**RE: Sea Link (EN020026) Nationally Significant Infrastructure Project (NSIP) Application – Written Representations (Deadline 3A – Change Request) – Kent Wildlife Trust (F0B50218B)**

Kent Wildlife Trust's ("KWT") Written Representations for Deadline 3A, Change Request to the Development Consent Order ("DCO") will focus solely on Change 1 – Access at the Hoverport, Kent, which is described in National Grid's, (the "Applicant"), Document 9.76.3: Change Request Consultation Report as:

HABITATS OF PROTECTED SPECIES AND IMPORTANT HABITATS - KENT

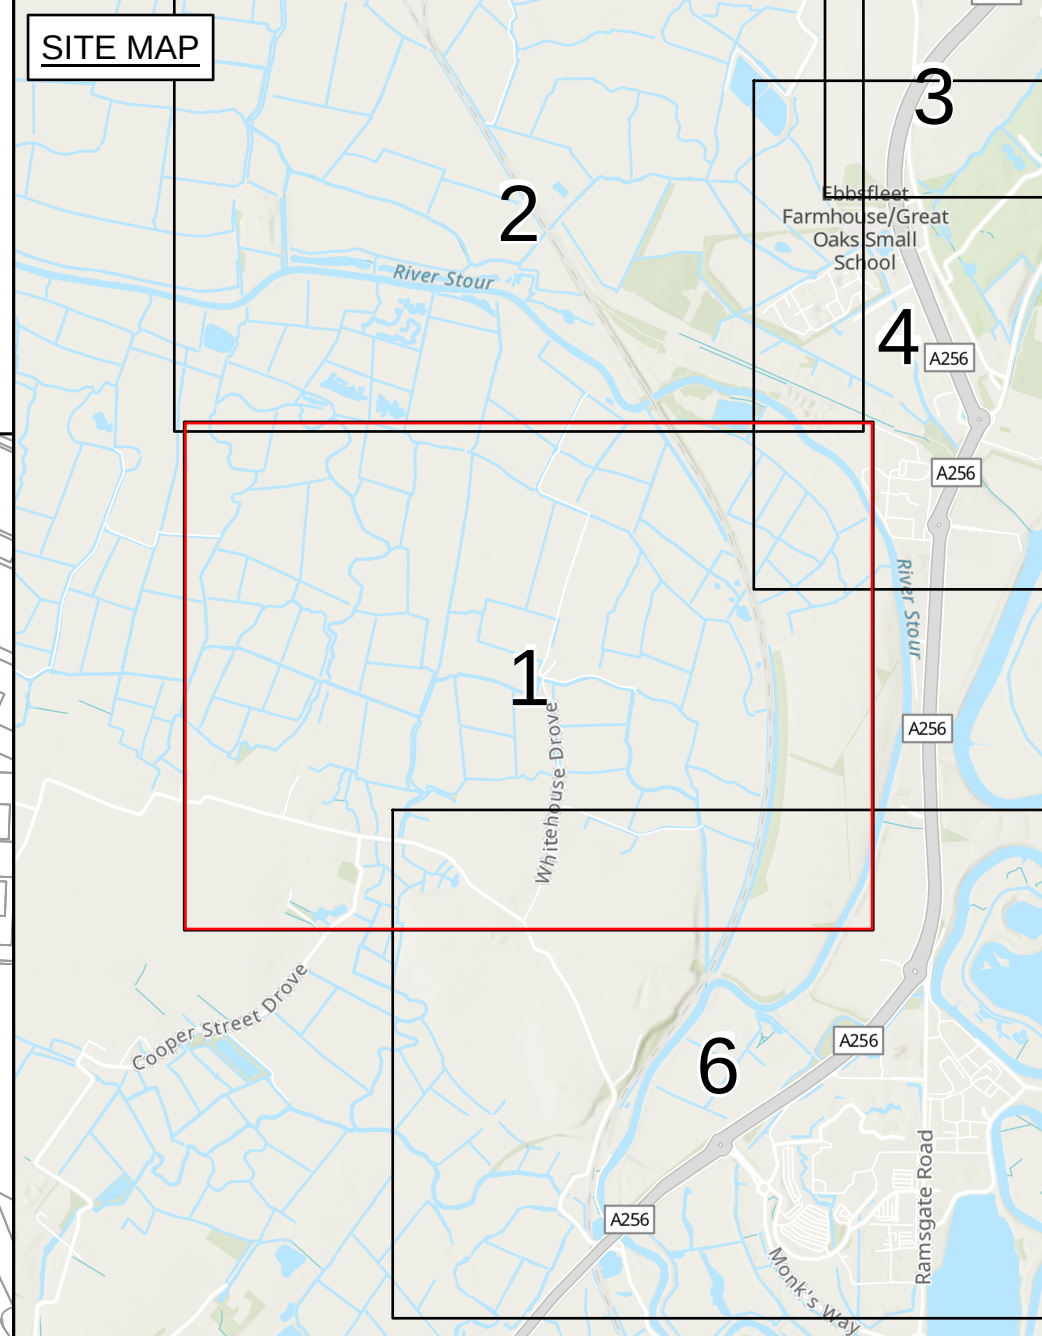
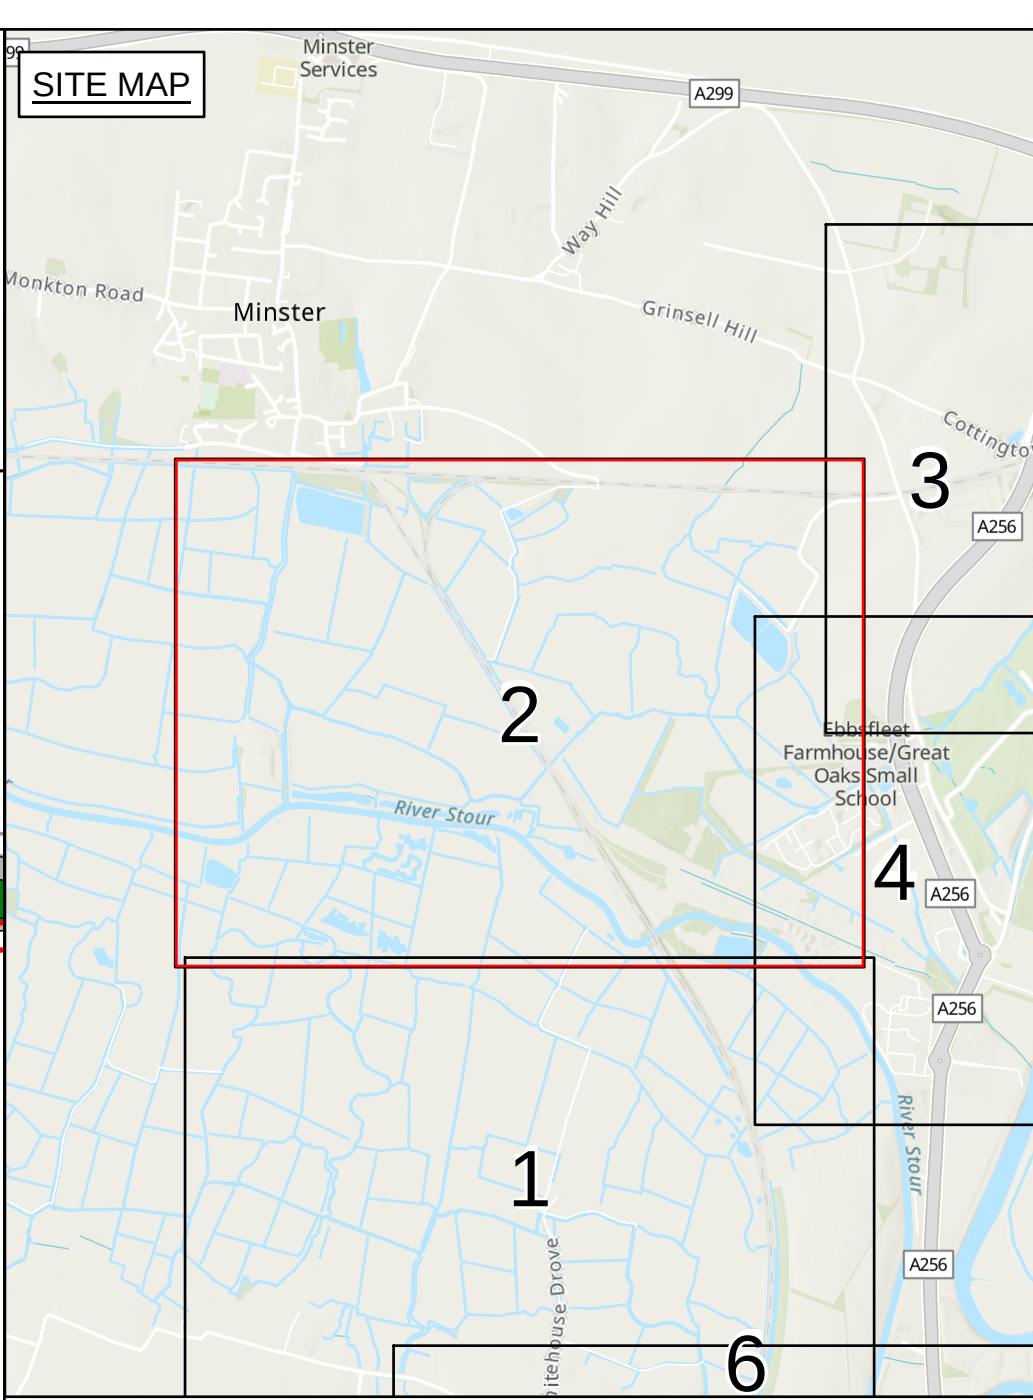
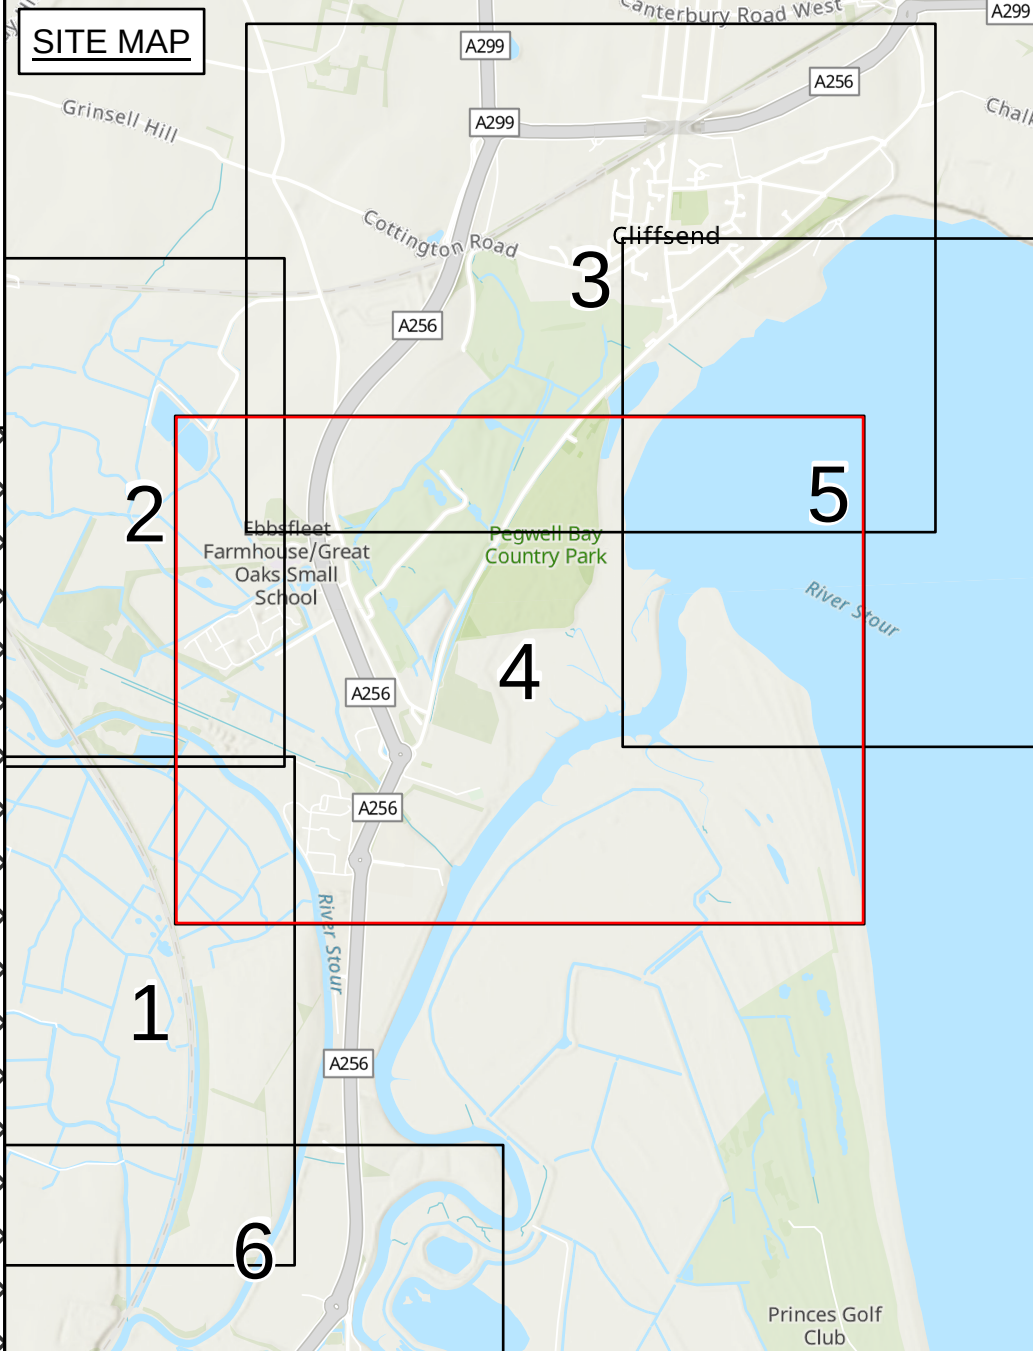
KWT recognises, in principle, the stated intention behind this Change Request, namely, to provide flexibility to select an access route that avoids encroachment onto saltmarsh habitat and thereby reduce the risk of direct impacts. However, after reviewing Document 2.9.2: *Habitats of Protected Species and Important Habitats – Kent*, we are concerned as to why saltmarsh has been omitted from the plans. When reviewing this document, in particular plan DCO/K/HA/PS/0810 (sheet 3 of 6), saltmarsh is not a habitat listed under the 'Legend' and is not annotated on the plan. As saltmarsh is both a Section 41 Priority Habitat and a qualifying feature of national and international designated sites, its omission from a document explicitly titled "*Habitats of Protected Species and Important Habitats*" represents a material deficiency in the Applicant's environmental information. This omission undermines confidence in the Applicant's ability to avoid impacts in practice and prevents meaningful scrutiny by the Examining Authority ("ExA") and Interested Parties. Without saltmarsh being accurately mapped and referenced within the relevant plans, there is no clarity that the habitat can be or will be avoided during construction, operation or maintenance.

- Saltmarsh habitat is clearly annotated on all plans and documents to ensure that no areas of saltmarsh fall within the proposed access route;
- Comprehensive ecological surveys of the hoverport are undertaken prior to any approval of revised access arrangements;
- Any access route is survey-led, avoids impacts to protected species and their habitats, and is subject to consultation with relevant bodies; and
